WEST SUSSEX COUNTY COUNCIL CONSULTATION

TO:	Arun District Council FAO: Mrs A Gardner
FROM:	Highways, WSCC
DATE:	08/01/2019
LOCATION:	Land north of, 21, Ocean Drive, Ferring, Worthing, BN12 5QN
SUBJECT:	FG/191/18/PL Erection of 2 No. 3 bed chalet style dwellings with associated parking, landscaping & bin store.
DATE OF SITE VISIT:	
RECOMMENDATION:	☒ Advice ☐ Objection ☐ Modification ☐ No Objection ☐ More Information ☐ Refusal
S106 CONTRIBUTION TOTAL:	£N/A

PROPOSED BIN STORE

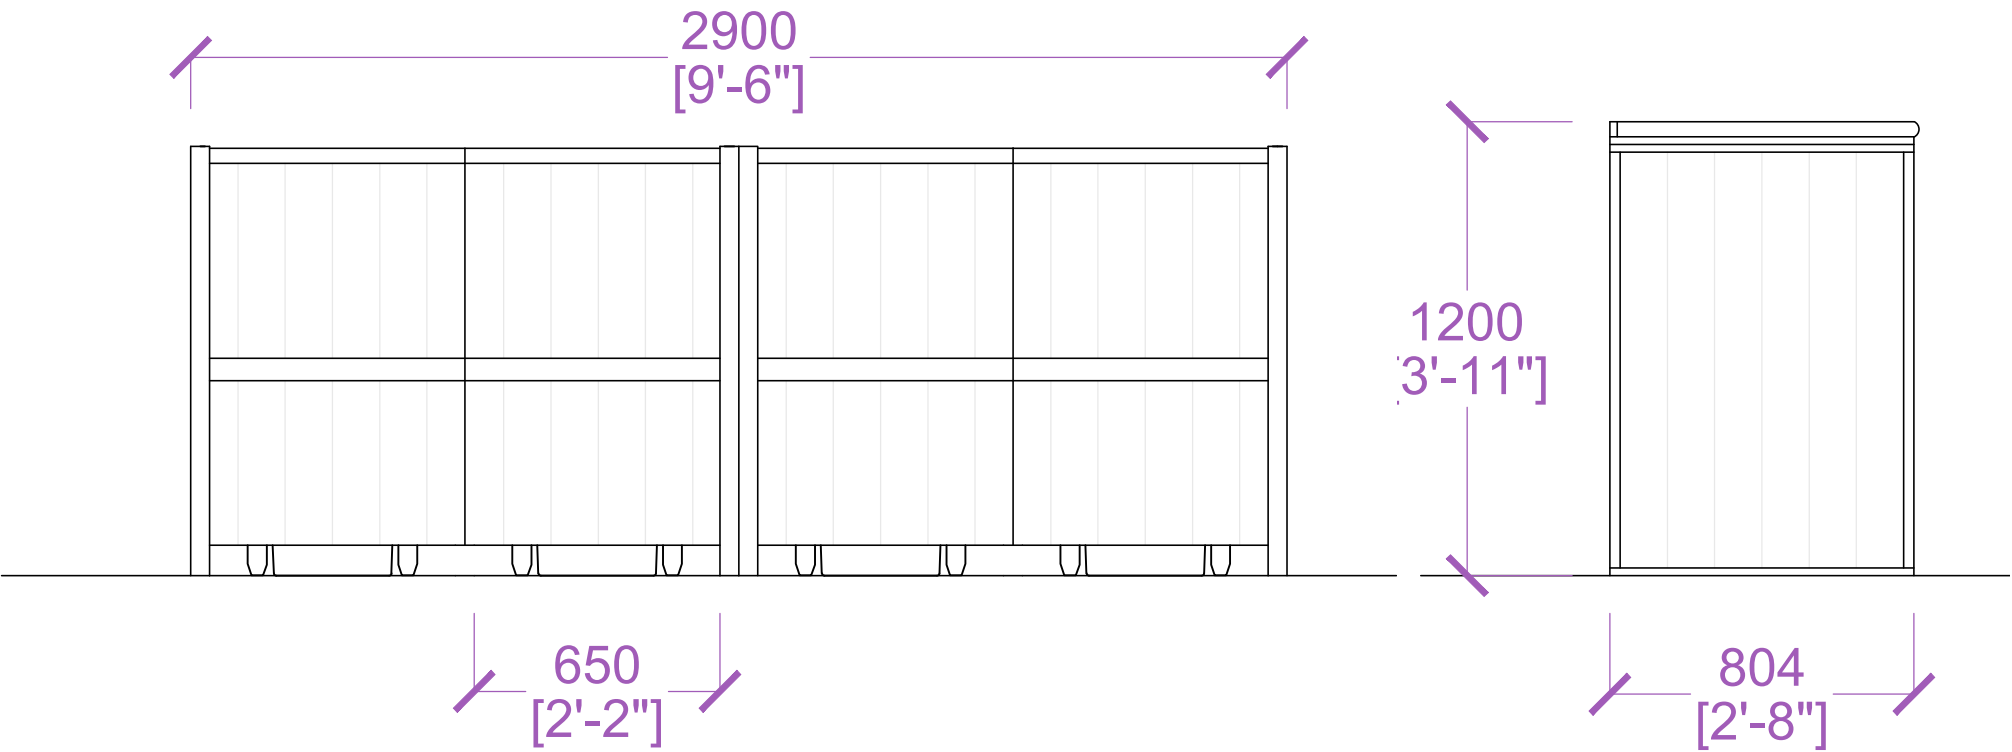
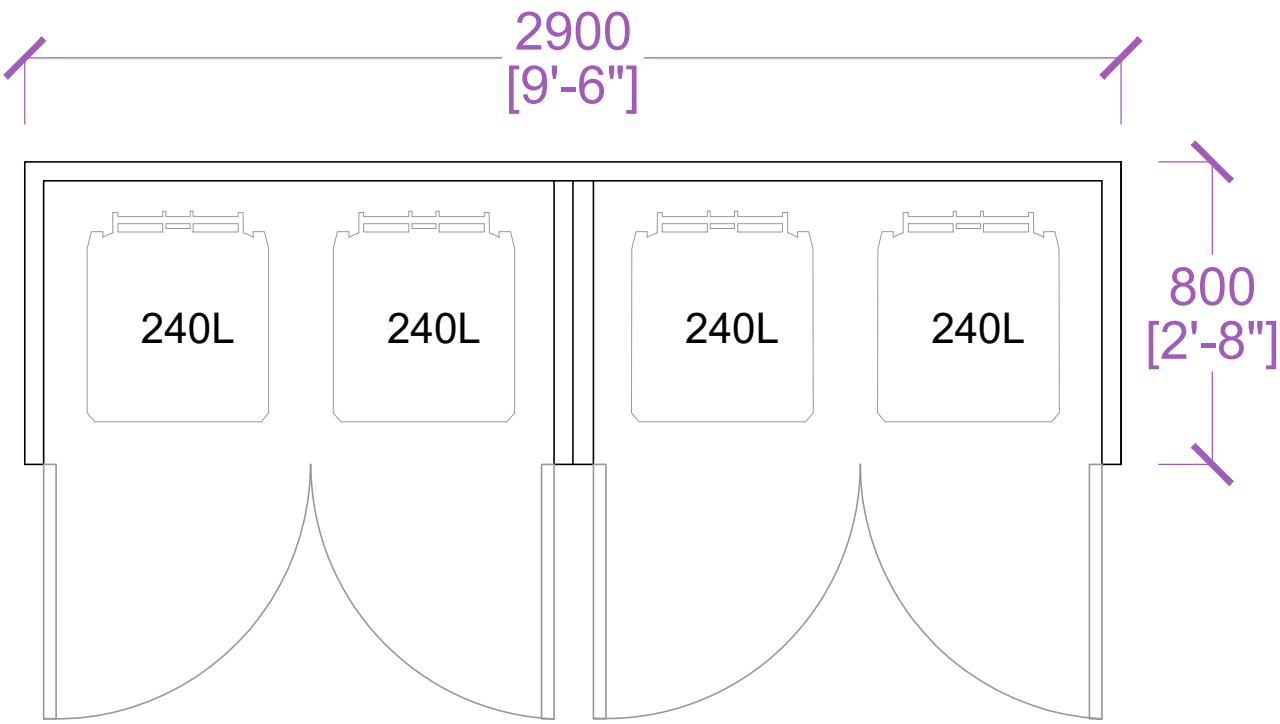
Two parking spaces have been demonstrated as serving each property; these spaces should measure 2.4 x 4.8m. It appears as though space is available for vehicles to turn and egress the site in a forward gear. It is anticipated that the existing refuse and recycling collection arrangements would be retained roadside, Manual for Streets does state that residents should not have to travel over 30m to put bins out and collection vehicles should not have to travel in excess of 25m to collect/deposit bins. This is however a matter of amenity for the Local Planning Authority (LPA) to consider. The applicant is advised to contact the waste disposal authorities to ascertain whether the practise would be acceptable.
